Gate Burton Energy Park

EN010131

Applicant Responses to Interested Party Submissions at Deadline 2
Document Reference: EN010131/APP/8.15
September 2023

**FIGURE NUMBER**  
Figure 4-7

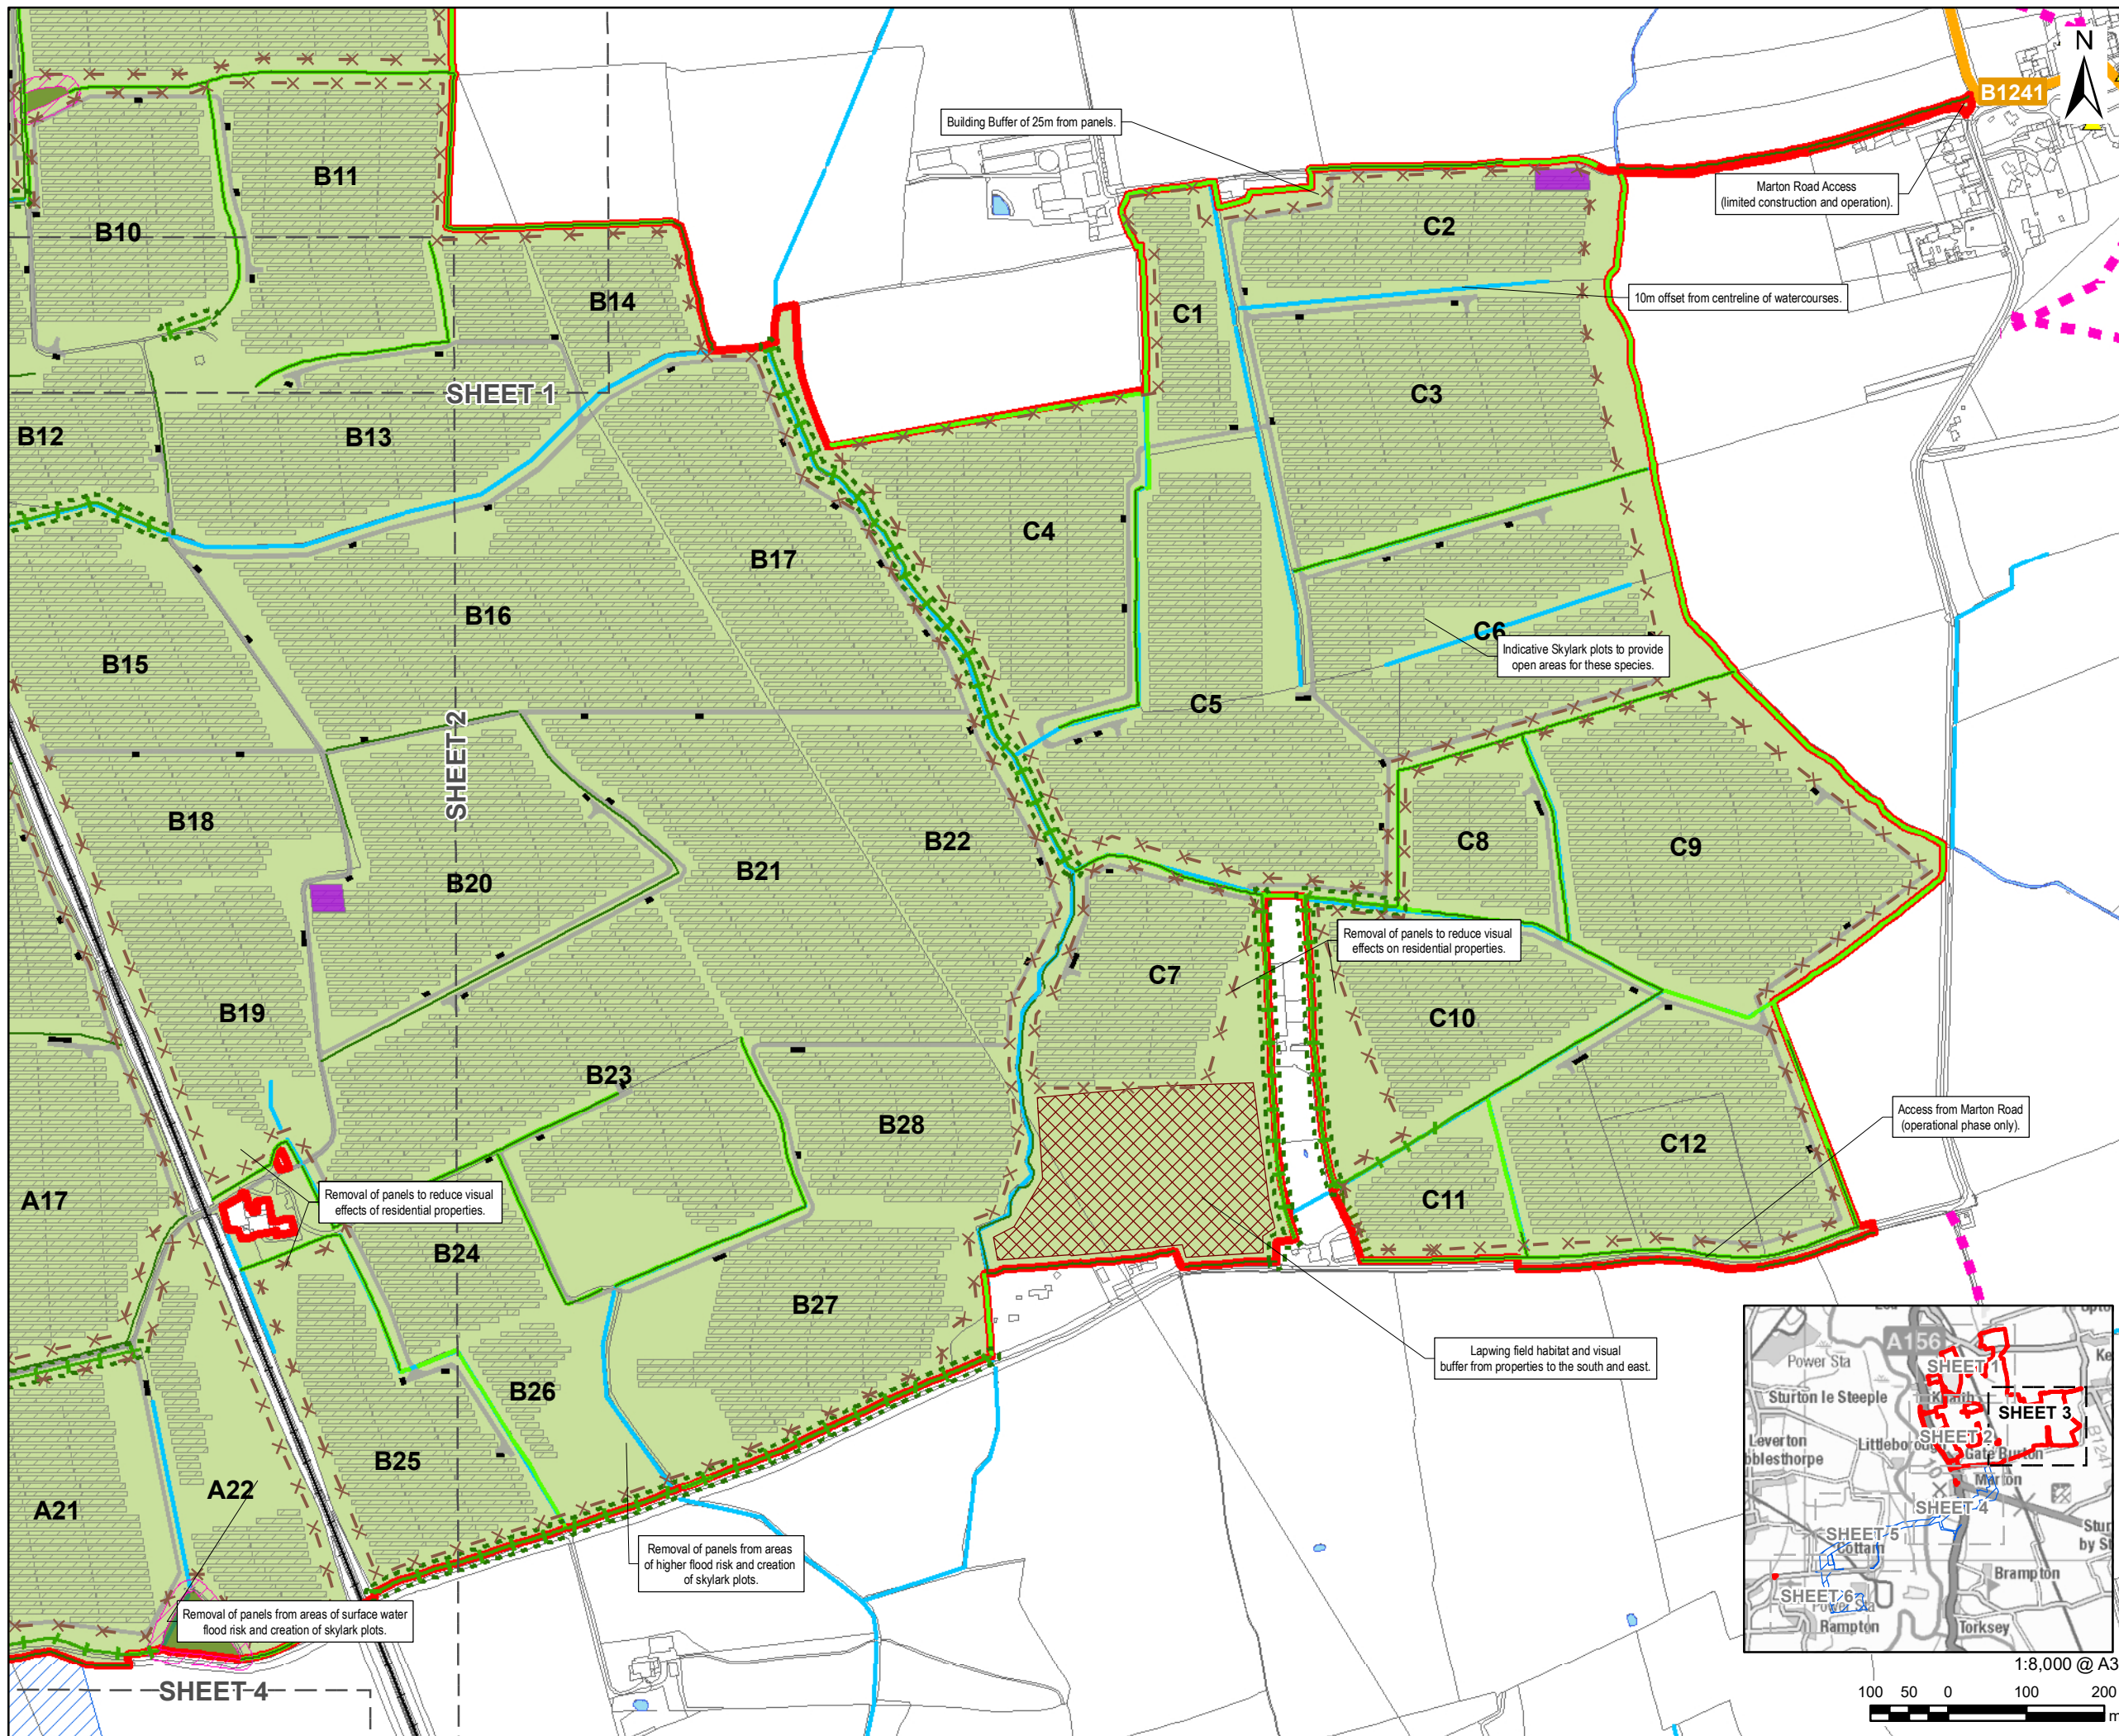
Response Reference	Question Number	Summary	Applicant response
REP2-053 (NCC)	1.7.6	<p>Re ExA question on Outline Design Principles (ODP) Heritage Setting Buffer (ES Volume 2: Figure 2- 4) – “Given the direct reference to Figure 2-4 [APP033] to identify the location of the Heritage Setting Buffer how is this to be secured as this is not identified as a certified document? If not, why not?”:</p> <p>NCC can confirm that the ‘heritage buffer zone’ is in Lincolnshire and does not affect Nottinghamshire/Bassetlaw. However, NCC do consider if the Burton Wood redline excluded area could be extended to take in A14 (the Heritage Buffer Zone).</p>	<p>The Heritage Setting Buffer located between Gate Burton Hall and Burton Wood has been agreed in consultation with Historic England and therefore cannot be removed.</p>
